WILPINJONG COAL PTY LTD

24 May 2019

**RE: Submission – Wollar Solar Farm Environmental Impact Statement
[SSD-9254]**

Figure 2 | Project Site

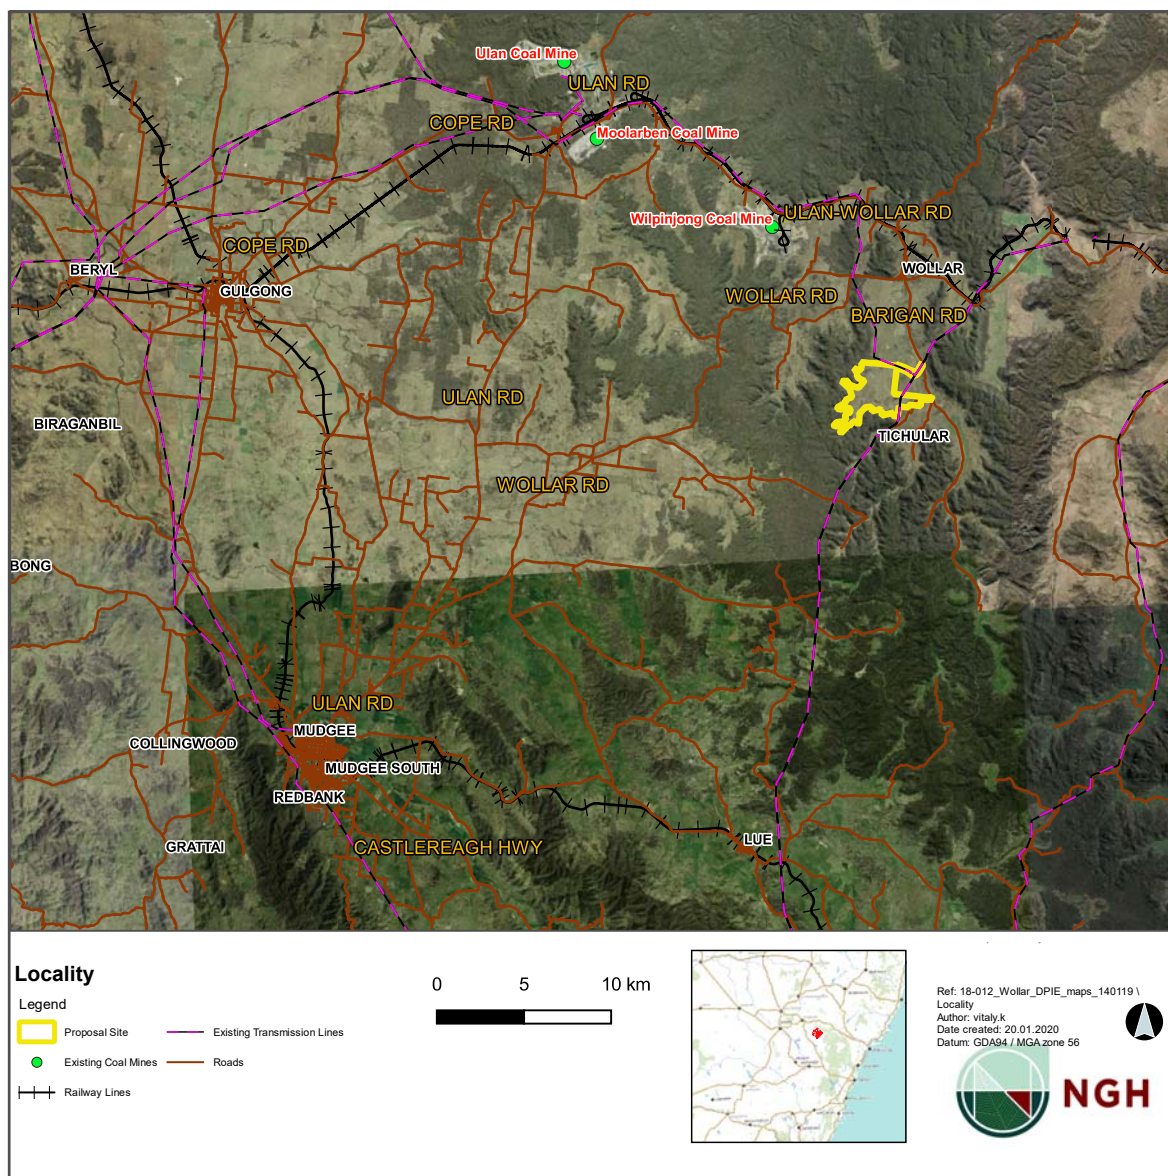
WSD may not be the proponent for the road upgrades because there is an agreement between the Mid-Western Regional Council and WSD for Council to be the proponent for these works. However, if WSD is to be the proponent for the works, it is not clear that the works are included in the EIS specialist assessments, as the proposal area provided on Figure 1-2 of the EIS does not include them (reproduced below).

WCPL therefore suggests that the Department seeks confirmation from Mid-Western Regional Council as to the proponent of the proposed Wollar Solar Farm local road upgrades.

Figure 8 | Road Upgrades

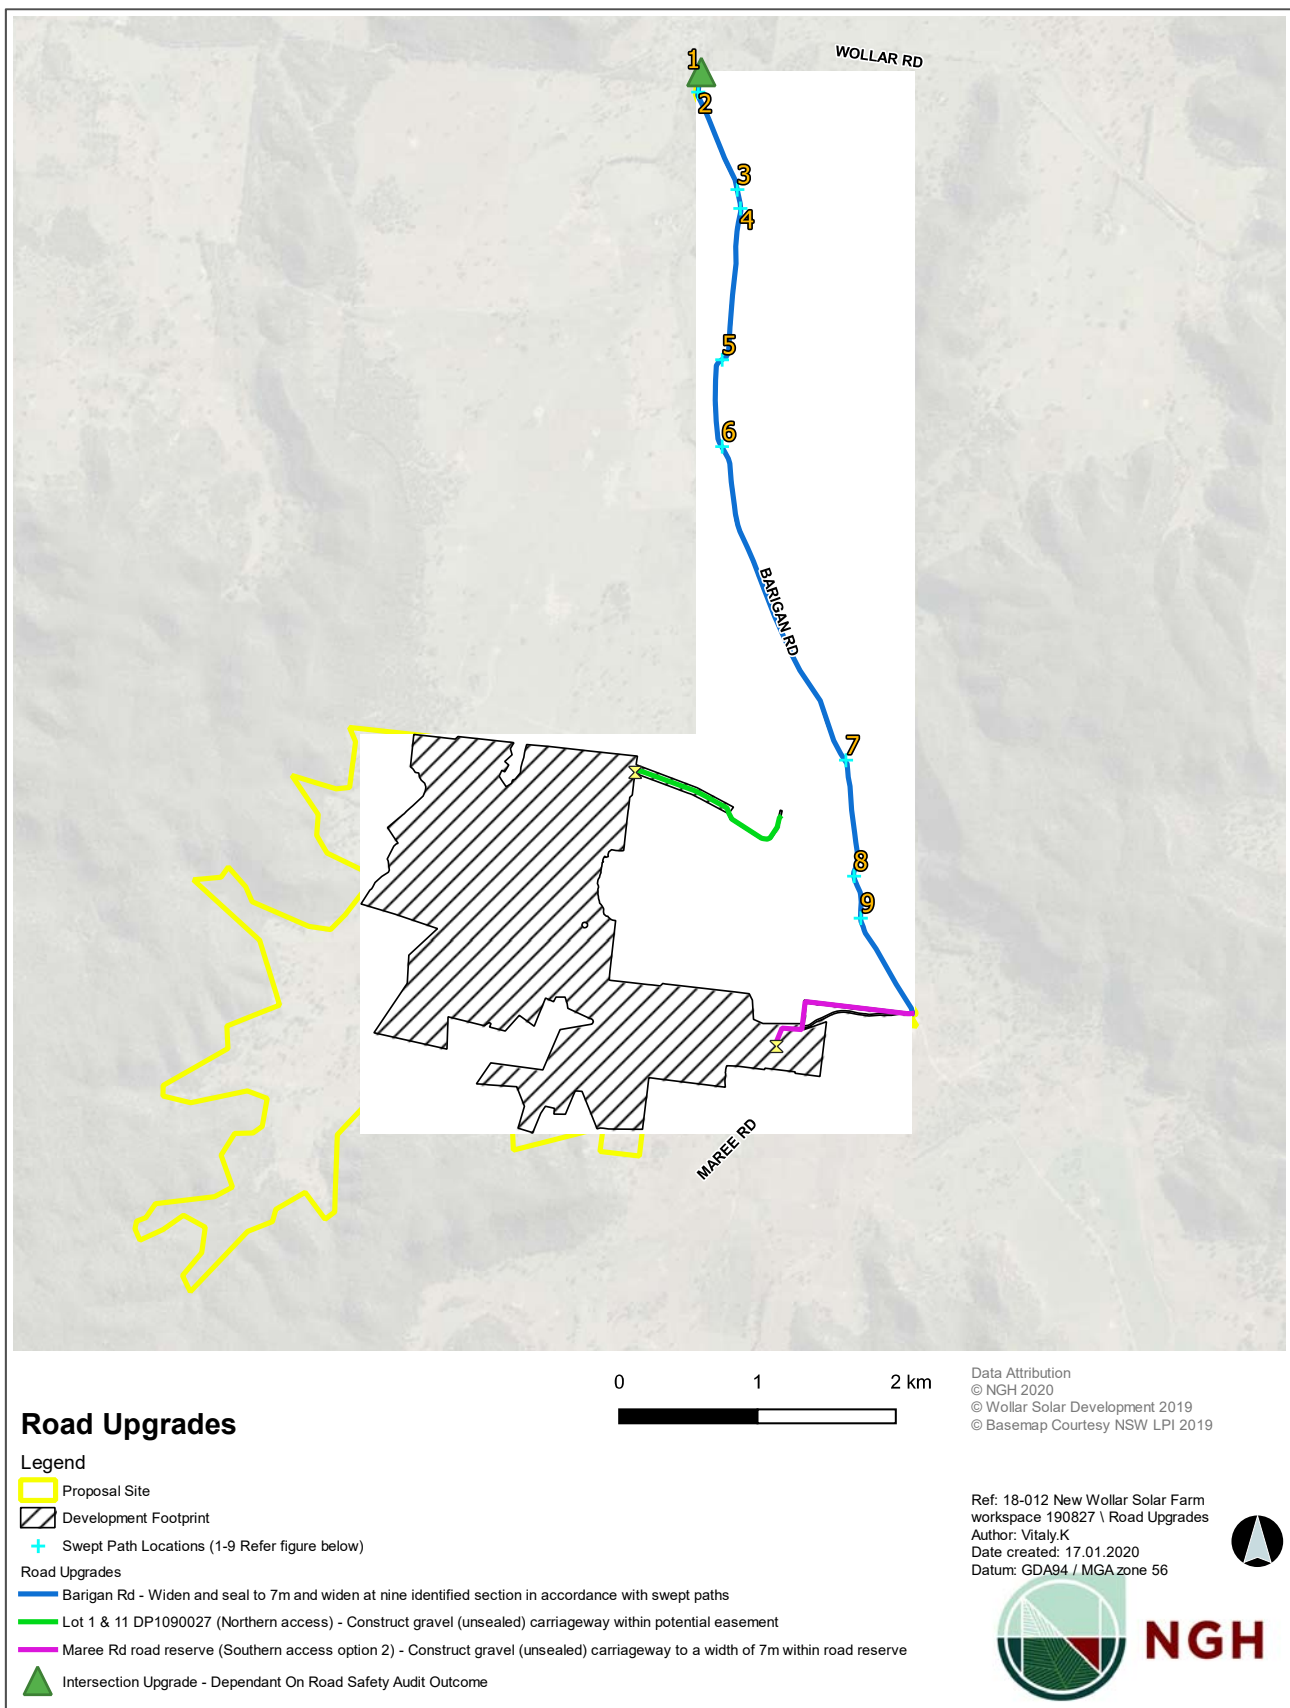
Based on the description in the EIS, it appears that WSD proposes to develop new passing facilities on Barrigan Road, which may involve land disturbance and potentially the clearing of remnant native vegetation within the road reserve.

WCPL's experience indicates that remnant vegetation in road reserves in the local area can include threatened ecological communities (i.e. remnants of previous communities that were widespread prior to agricultural development).
